National Office for Environmental Health Services  
2nd Floor, Oak House, Lime Tree Avenue  
Millennium Park, Naas, Co. Kildare  
Eircode: W91KDC2

### NEHS ref: ID5252

Enclosed are the observations of the National Environmental Health Service (NEHS) on planning application [An Coimisiún Pleanála - Case reference: PAX19.323579](#) Proposed Windfarm development of 7 Turbines, 110kV substation and associated works, within the townlands of Leitrim, Lumville, Ballinla, Clarkeville, Ballyfore Big, Ballyfore Little, Ballyeakin and Ballykilleen, in (Coolestown By) Co. Offaly ([www.ballinlawindfarmsid.ie](http://www.ballinlawindfarmsid.ie))

## **National Environmental Health Service Submission Report**

Figure 2-2: Wind Farm developments within 25km of the Proposed Development

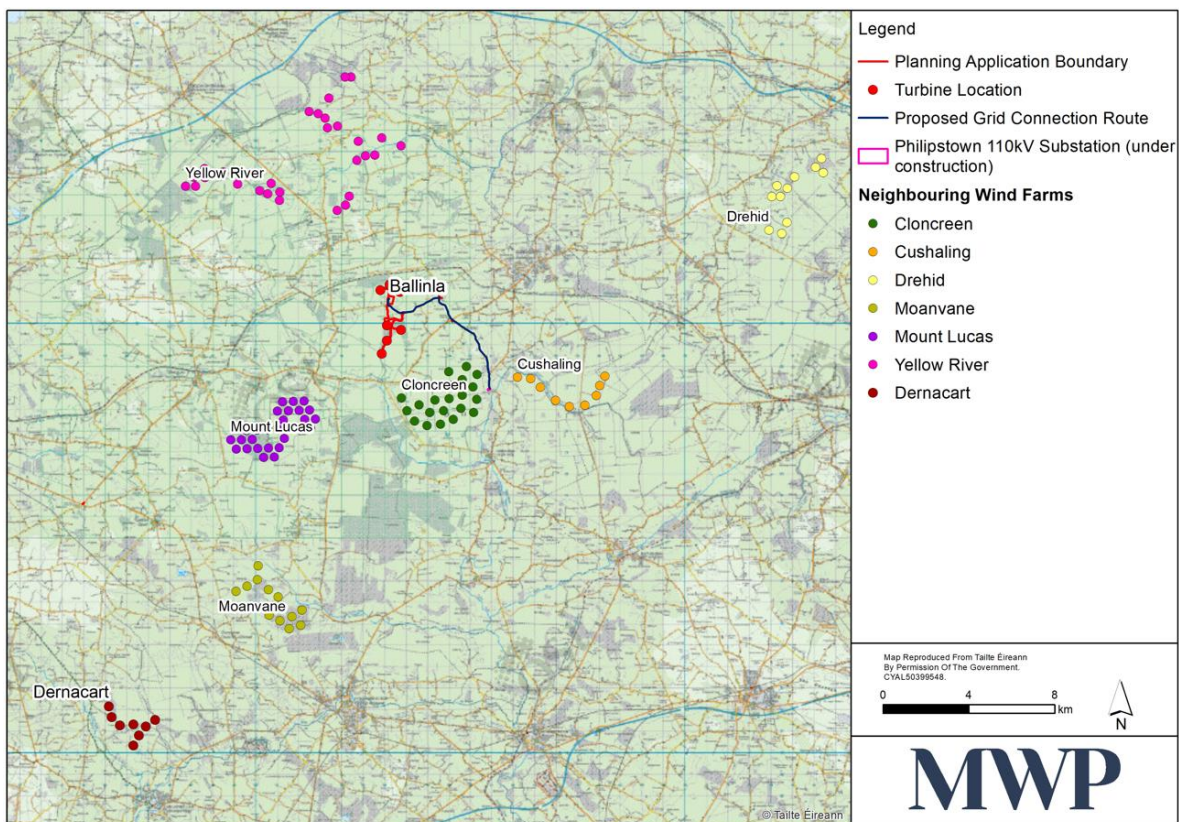
The NEHS notes the cumulative impact assessment with existing windfarms detailed in figure 5.6.
